**From:** Regina Okoye  
**Sent:** Thursday, December 12, 2019 1:24 PM  
**Subject:** FW: Winrock Hotel DRB PR-2019-001579

RE: **Marriot Suites at Winrock  
Conceptual Grading and Drainage Plan Resubmittal  
Hydrology File: J19D0581**

**RE: MARRIOT HOTEL AT WINROCK MALL – DRB PROJECT NUMBER: PR –2018-001579**

CONCEPTUAL-NOT-FOR-CONSTRUCTION

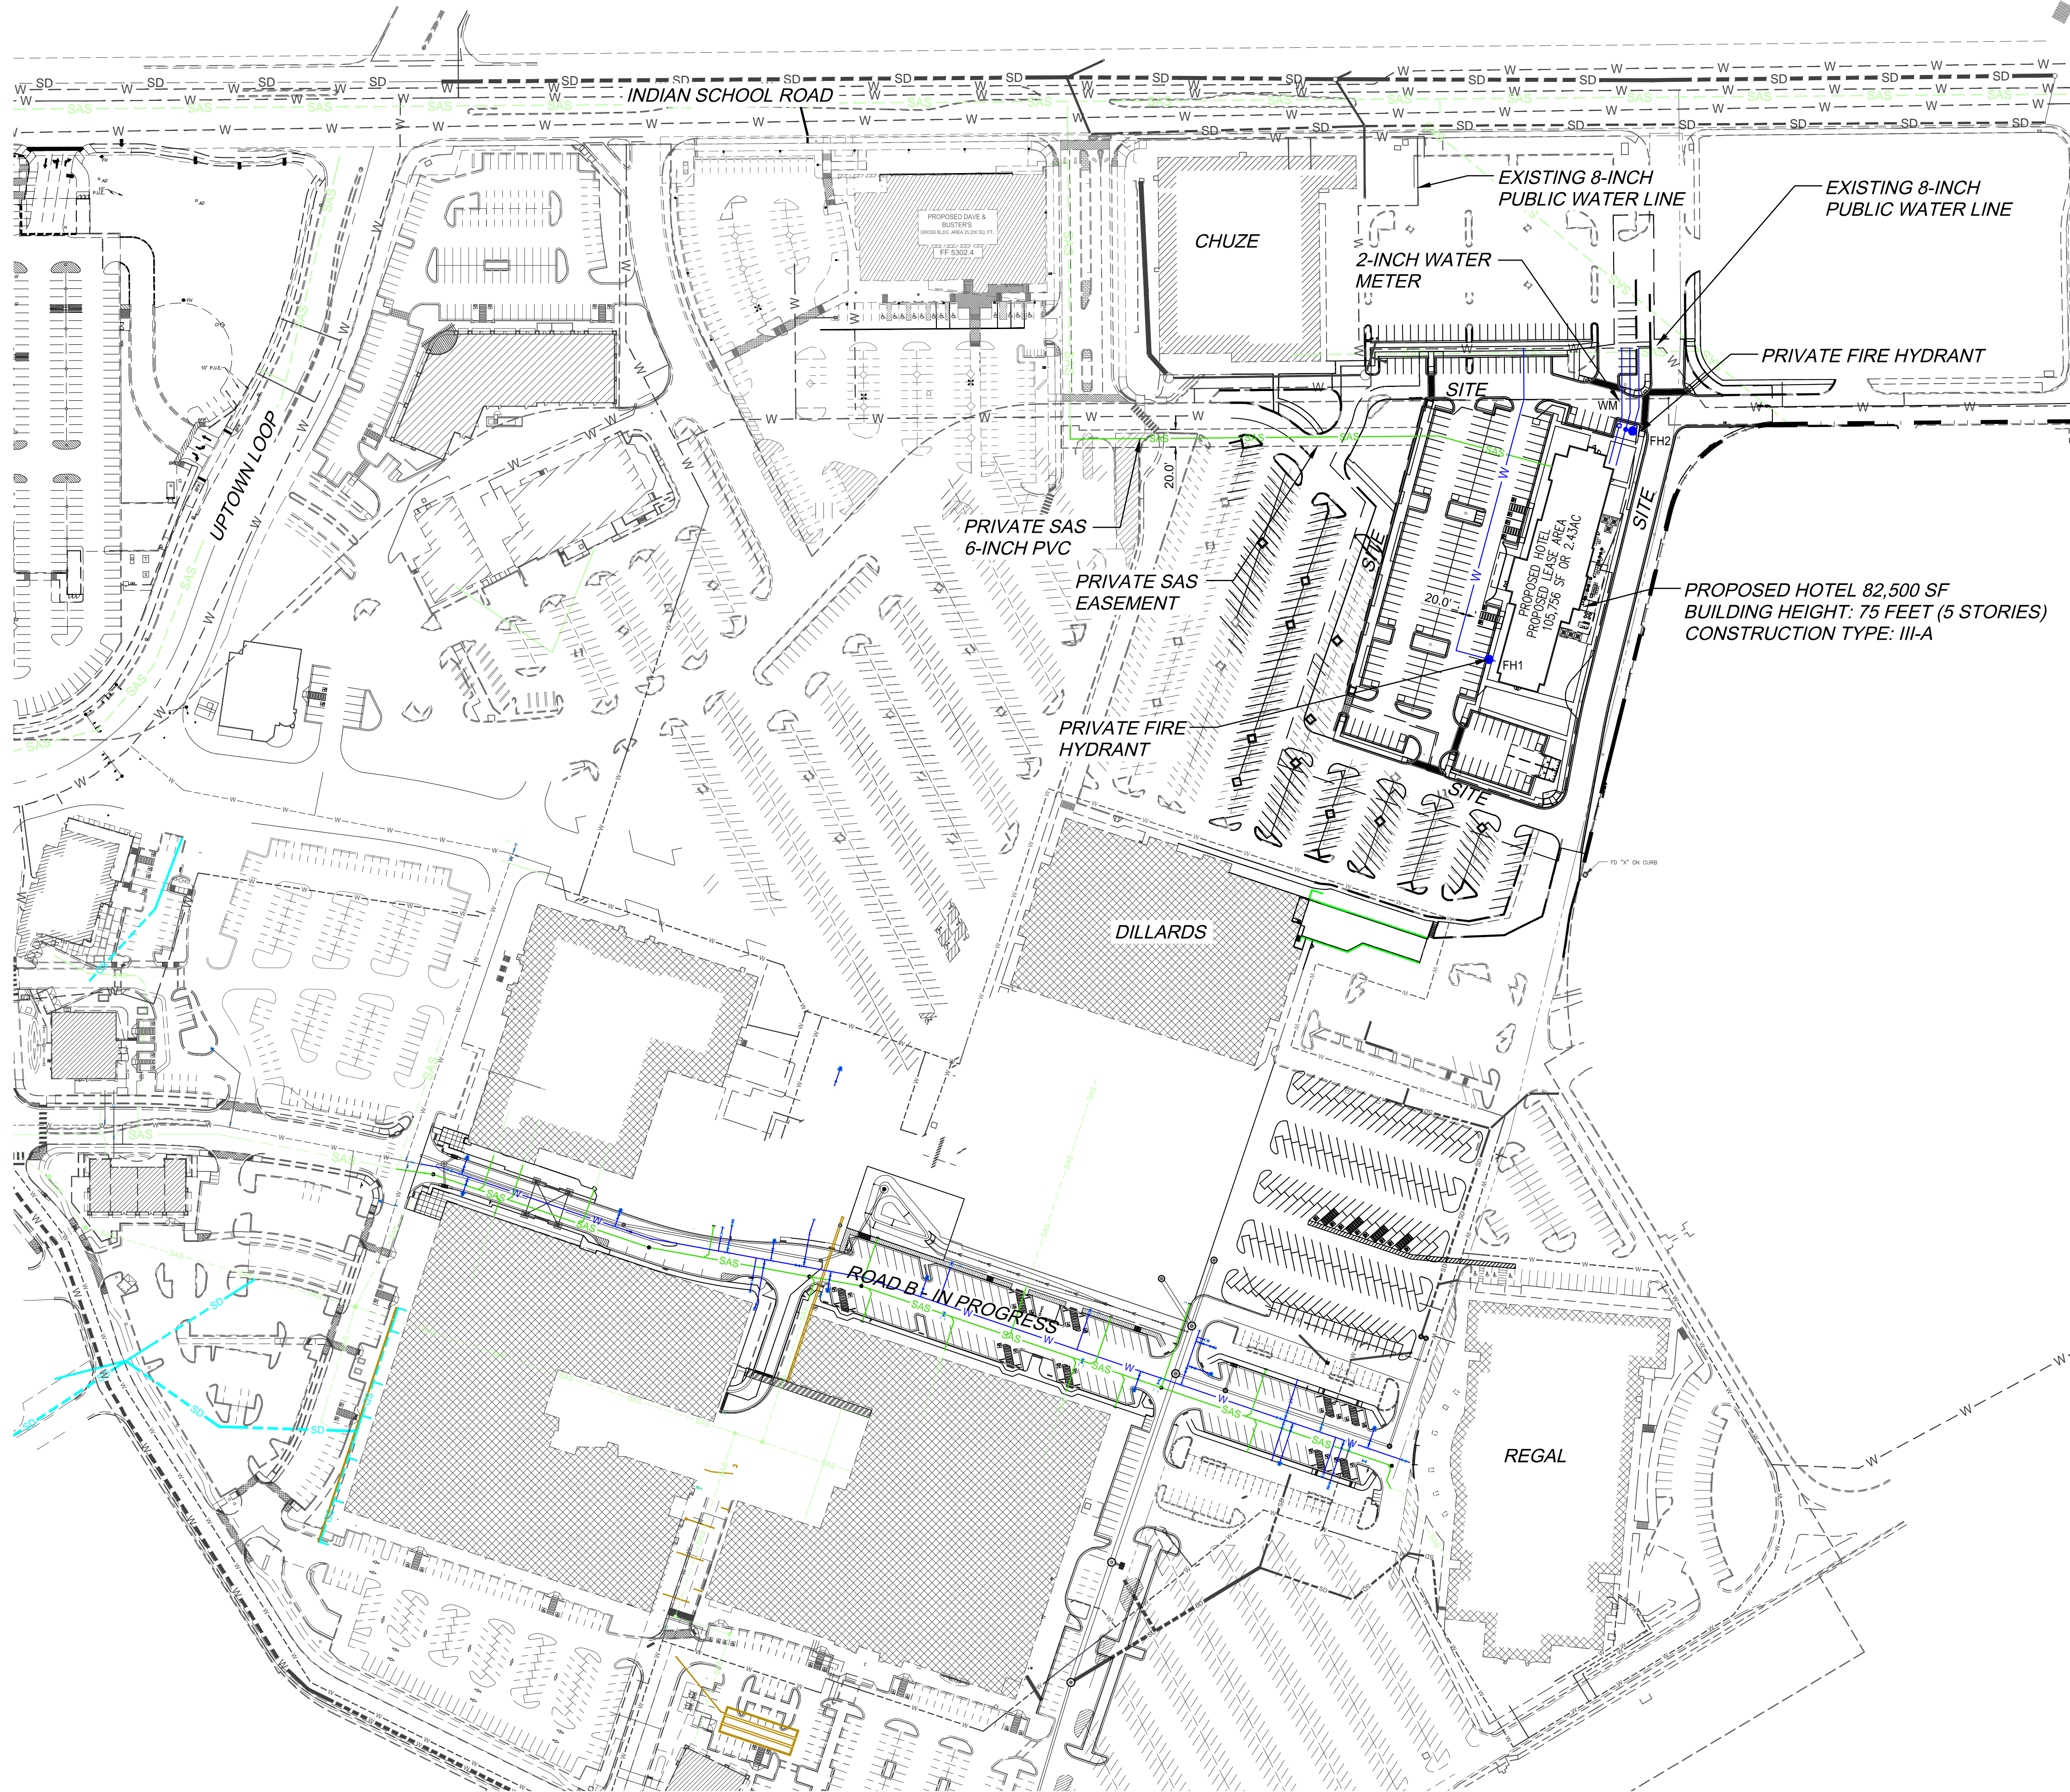
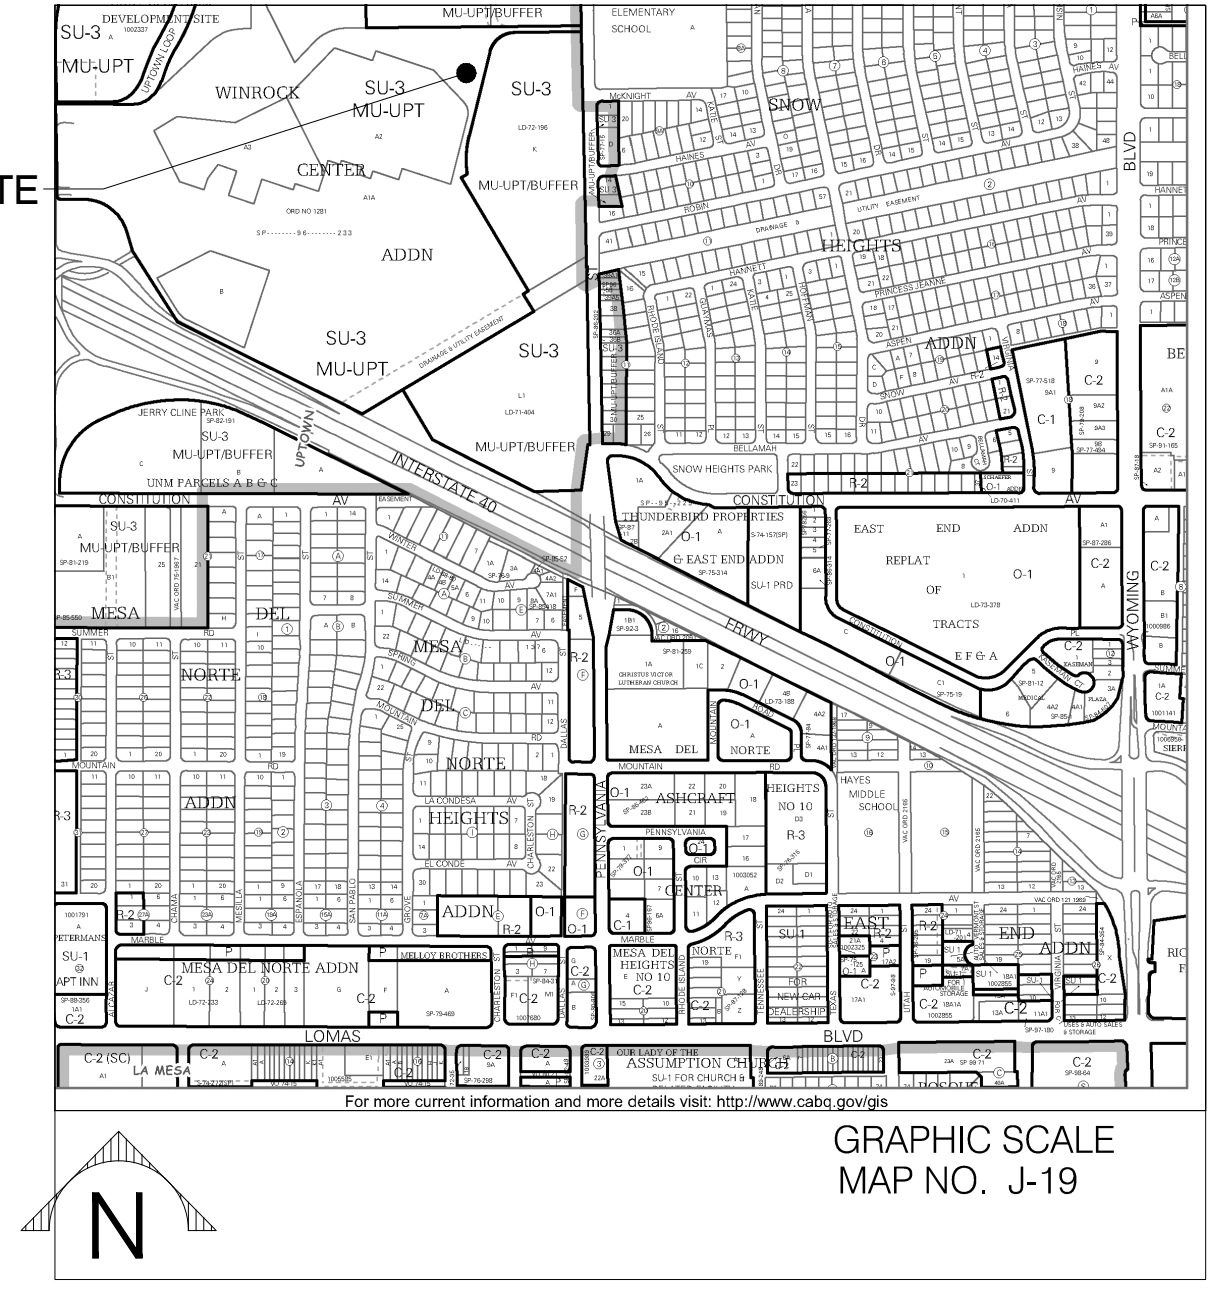
1. Please provide the stormwater quality volume (SWQV) calculations for each basin draining to each pond. The stormwater quality ponds need to be sized for the areas draining to them. Additionally, large portions of the site do not appear to drain to any pond.

- *SWQ #3 thru #18 are micro ponds within the parking islands.*
2. You may elect to make Payment-in-Lieu of onsite management for the volume not captured. In order to pursue this, the plan must state that: you could provide onsite management, you do not want to (due to cost or convenience), and you are electing to make the Payment in Lieu of onsite management.

- *Payment in-Lieu shall make up the difference between required and provided storage.*
3. This site qualifies as redevelopment and is only required to retain runoff from the 80<sup>th</sup> percentile storm (Vol. =  $0.26 \times \text{Imp. Area}$ ).

- *Plans have been labeled "Conceptual-Not for Construction".*
5. The land treatments in the existing and proposed hydrology calculations are not reflective of the site and the proposed work.

6. Additional detail, per the DPM Ch. 22.7 *Grading Plan Checklist*, is required:
  - a. Discussion and impacts of upstream offsite flows are missing.
    - ***Off-Site Flows do not enter the site. Language has been added to sheet C100.***
  - b. Proposed contours are rough and seem to ignore curbs, waterblocks and other site features.
    - ***Additional modeling has been done to provide additional clarity of proposed topography.***

7. Drainage features such as curb cuts, rundowns, roof drains, etc... should be identified at this stage; specific hydraulic calculations and exact locations may be deferred to Building Permit.
  - ***Curb cuts, rundowns and roof drains are shown on sheet C102.***

- *Sub-basin 100A discharges 2,635 cubic feet of storm water into SWQ #1 which has a capacity of 2,921 cubic feet of storage.*
  - *Sub-basin 100A discharges 2,859 cubic feet of storm water into SWQ #1 which has a capacity of 3,852 cubic feet of storage.*

- *Required Volume =  $112,650 \times 0.26/12 = 2,440.75$  cubic feet*
  - *Provided Volume (swq #3 + swq #18) @ 6-inch depth = 2,022 cubic feet.*
4. Label the Plan as "Conceptual – Not for Construction" or similar.

- *Existing land treatments have been changed to 0% A, 0% B, 3%, C and 97% D.*
  - *Proposed land treatments have been changed to 0% A, 0% B, 3%, C and 97% D.*
